DELEGATED REPORT

APPLICATION NUMBER	S6/2005/0225/FP and S6/2005/0226/LB
LOCATION	Mymwood House, Shepherds Way, Brookmans Park, Hatfield
PROPOSAL	Alterations and Extensions to Care Home

Drawing No JDA/03/940/P.APP/LAYS.001

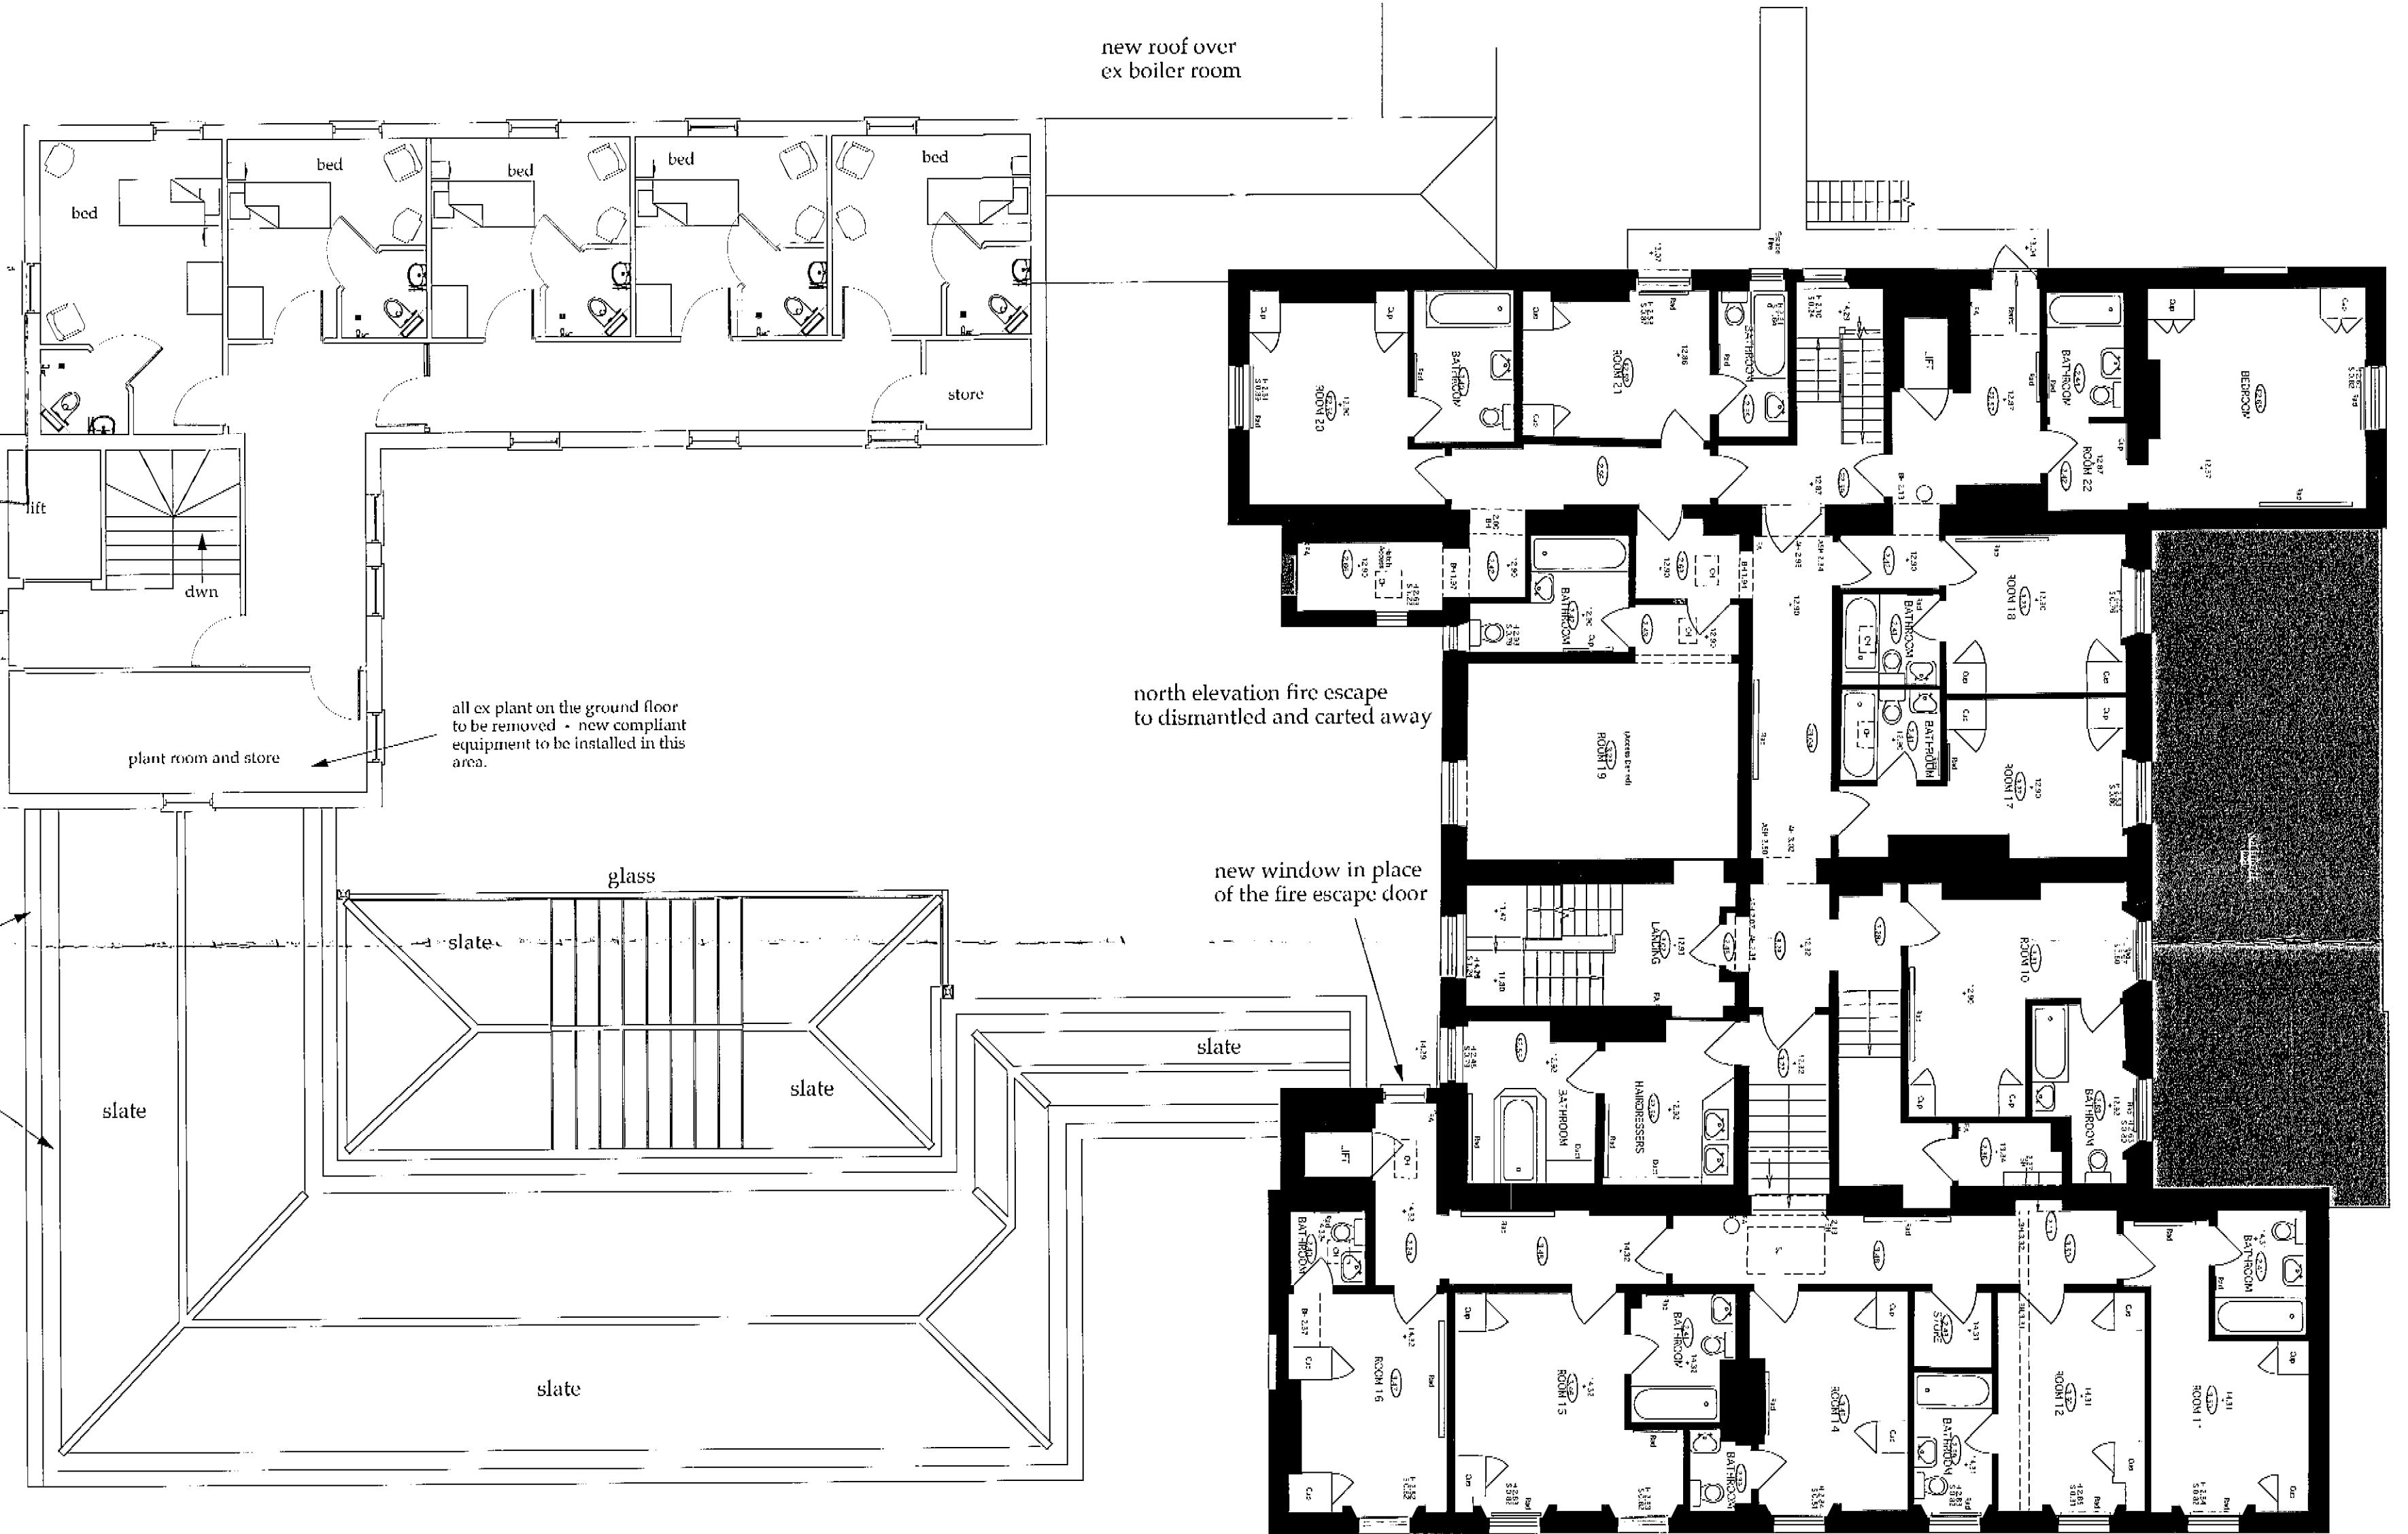
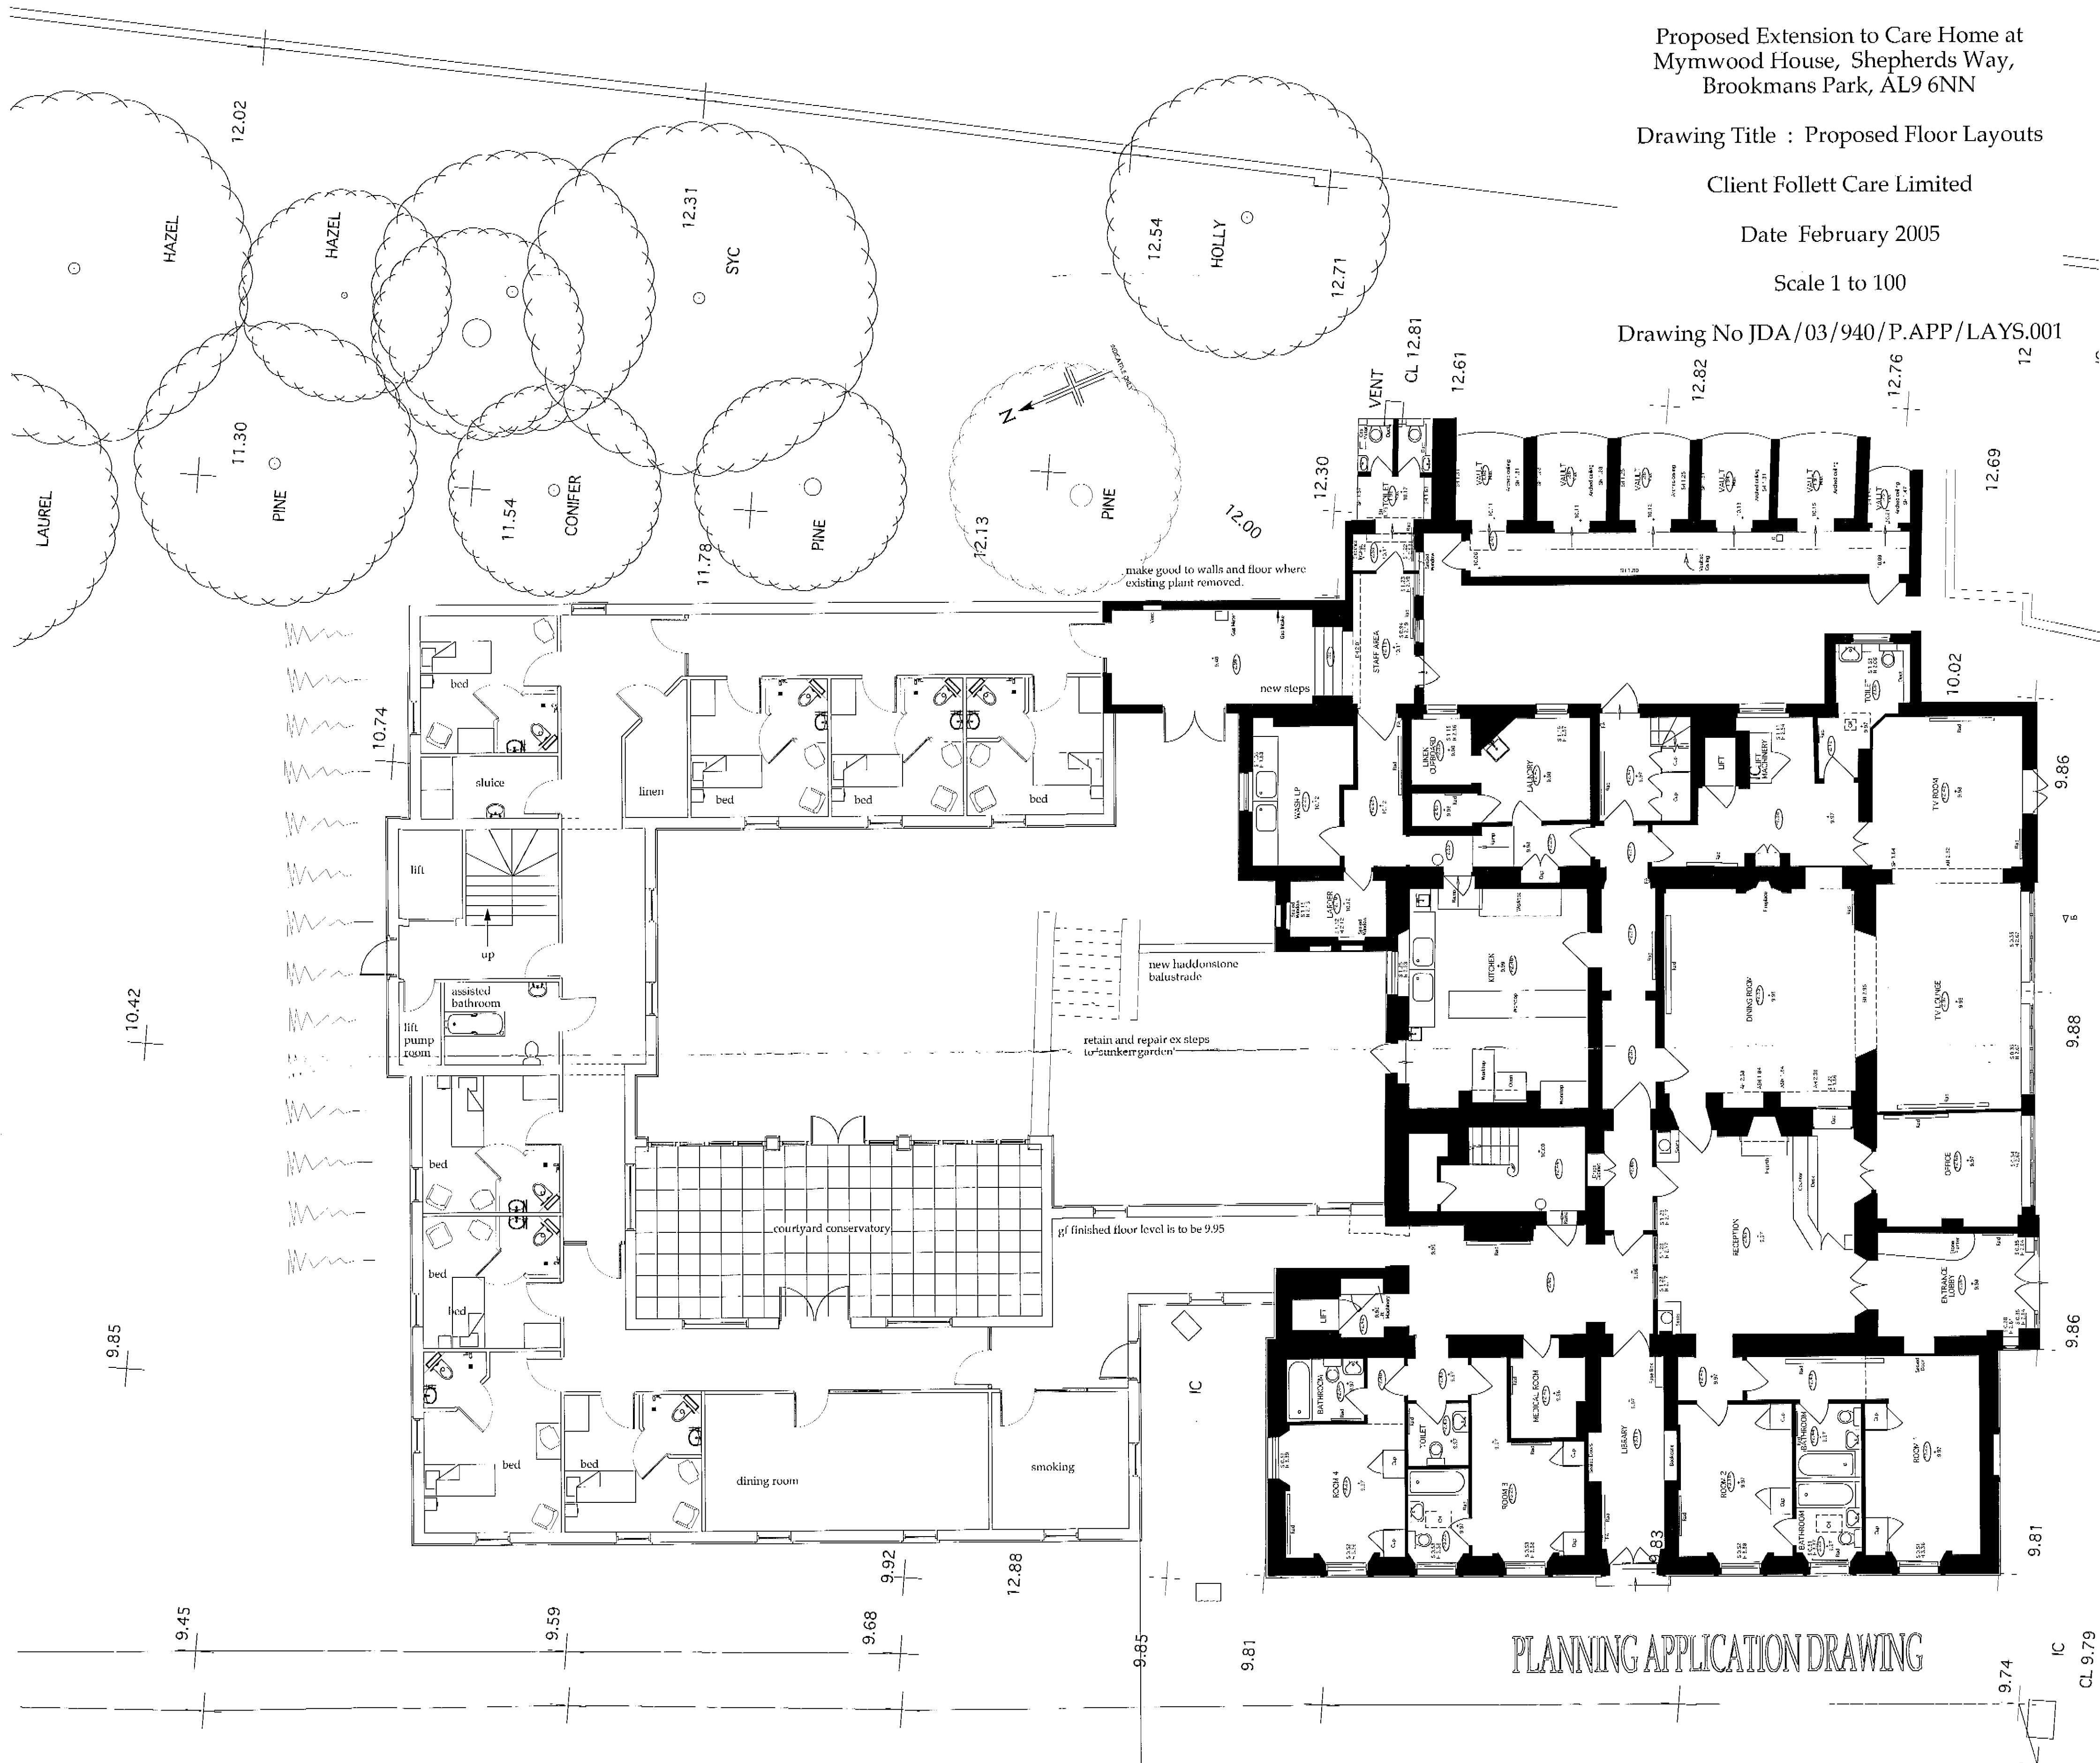
It is considered that the form and location of the extension proposed represents an unacceptable increase in the overall bulk and size of this building within the Green Belt. An extension of this size and design would make the building significantly more prominent visually, and this is particularly unacceptable in terms of its impact on open Green Belt land to the west.

When Mr Craig and I visited the site on 23 March 2005, we discussed the possibility of locating the two storey block, if one is required, at the rear of the site i.e. on the eastern side of the courtyard, although a simple extension incorporating a single storey block ranged around an attractive courtyard would be preferred. However, Mr
